5th May, 2013

Subject: Section 75W Modification Applications – Modification request to amend the Concept Plan (MP09_0162 MOD 4) and Project Approval (MP10_0177 MOD 13) regarding the expansion of the Child Care Centre as part of the residential development at 14-18 Boondah Road, Warriewood.

Project	Development Application Proposed Childcare Centre		
Project address	Lot 502 Macpherson Street, Warriewood		
Client	Meriton		
Title	Site Plan		
Drawn	Scale	Checked	
P.L.	1:200 @ A1		
Job No.	Drawing No	Issue	
2069	DA01	C

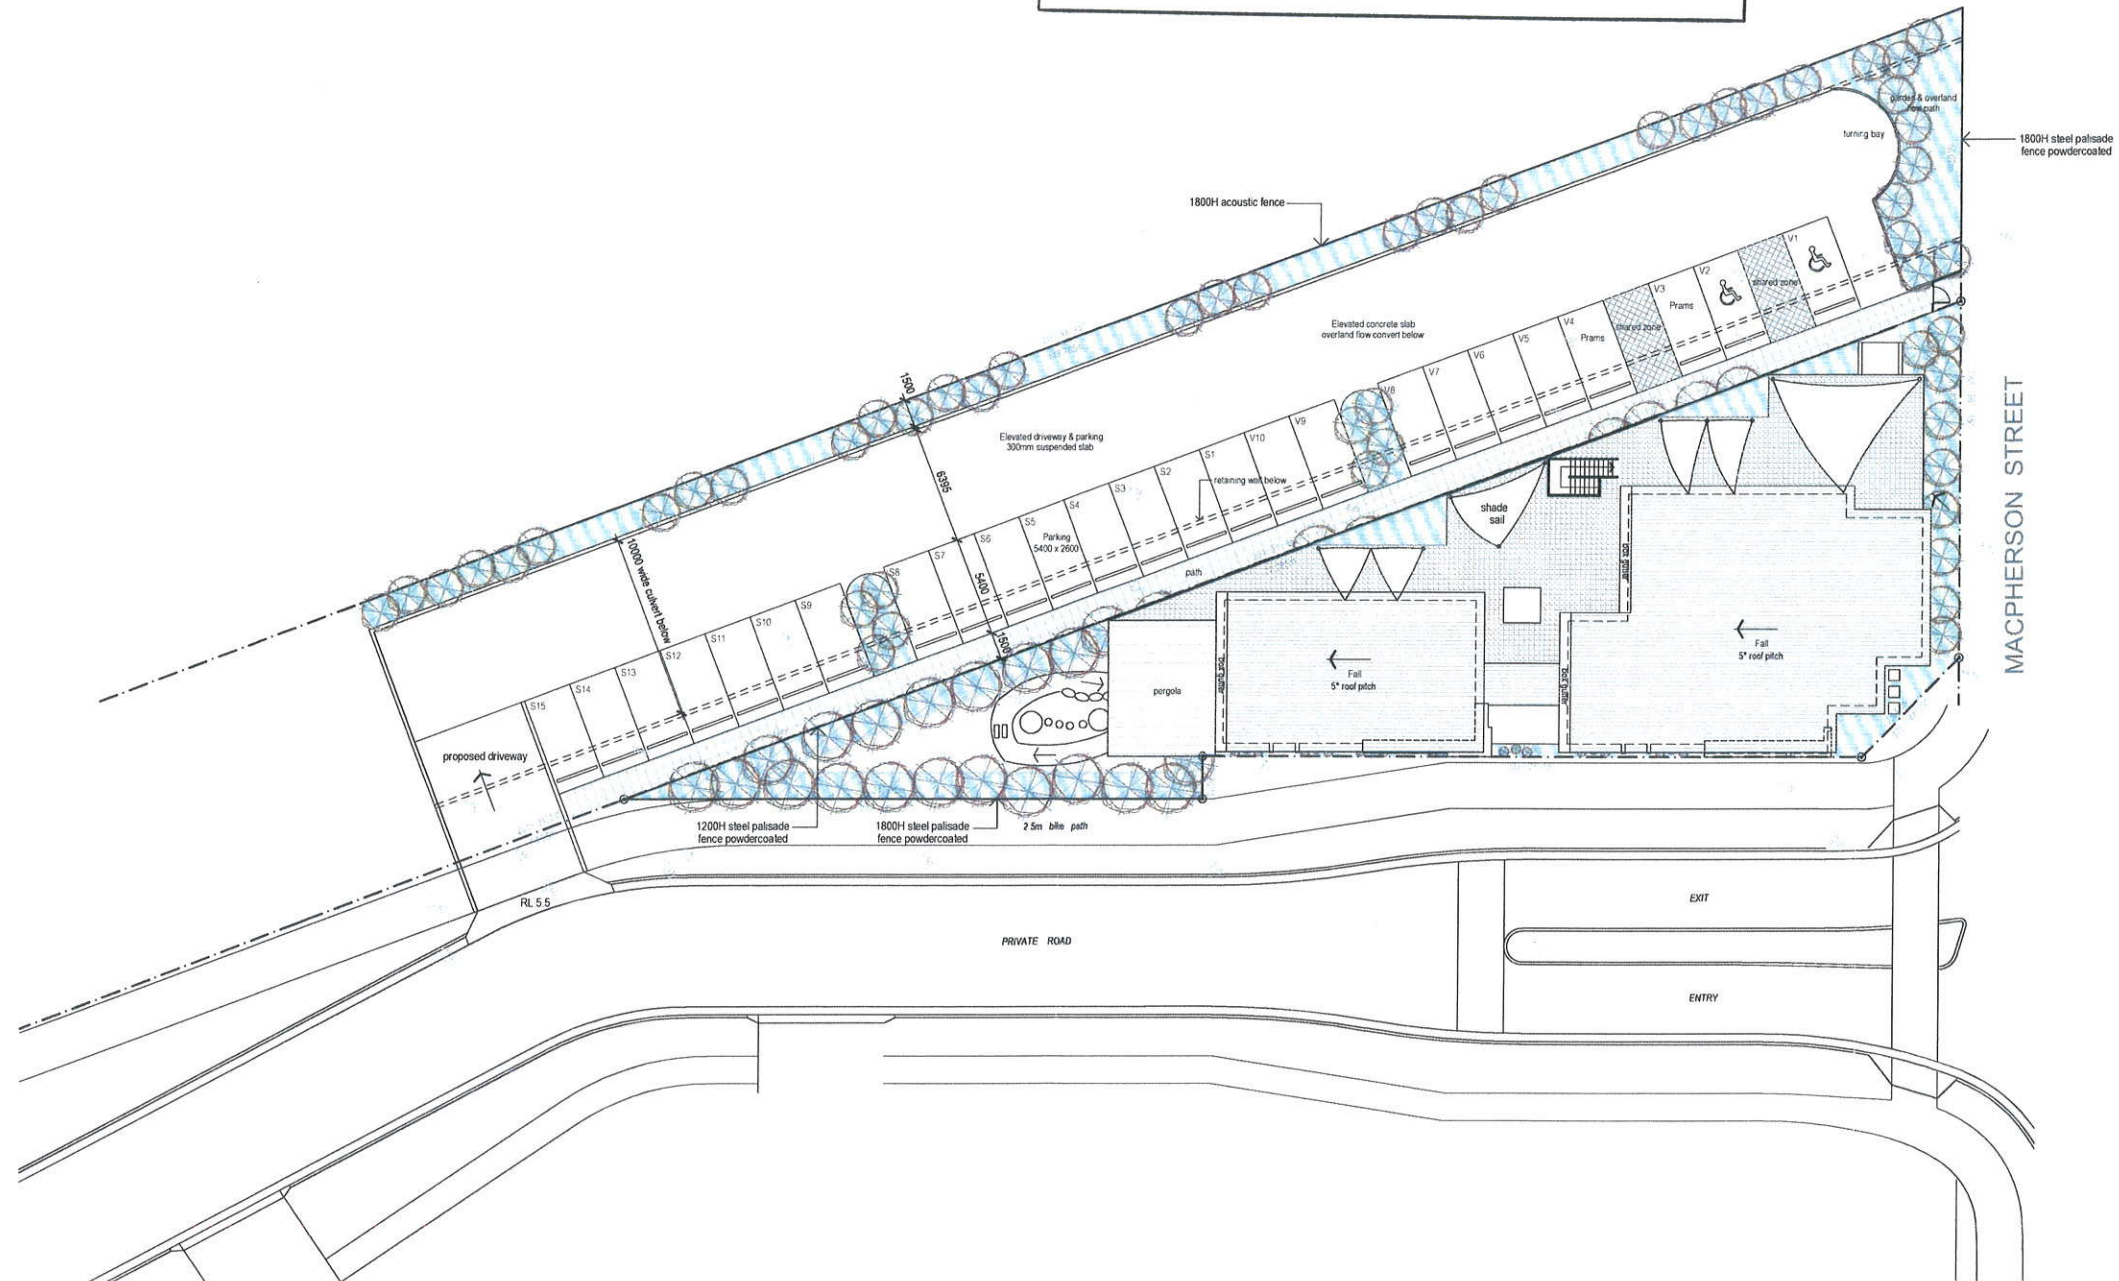
- 1 **Traffic** – The Child Care Centre driveway is directly opposite the ONLY entrance to our car park. With in excess of 220 units (in this section of the development) using this driveway the congestion during drop off and pickup times at the centre would be excessive and coincide to the times residents are leaving/arriving to and from their employment.
- 2 **Noise** – 100 children playing and communicating would make much more noise than 32 and as such hinder the peaceful enjoyment of our homes.
- 3 **Parking** – Staff for the centre would need to park in the street and parking is already an issue for the residents of Oceanvale and we are not yet to capacity.
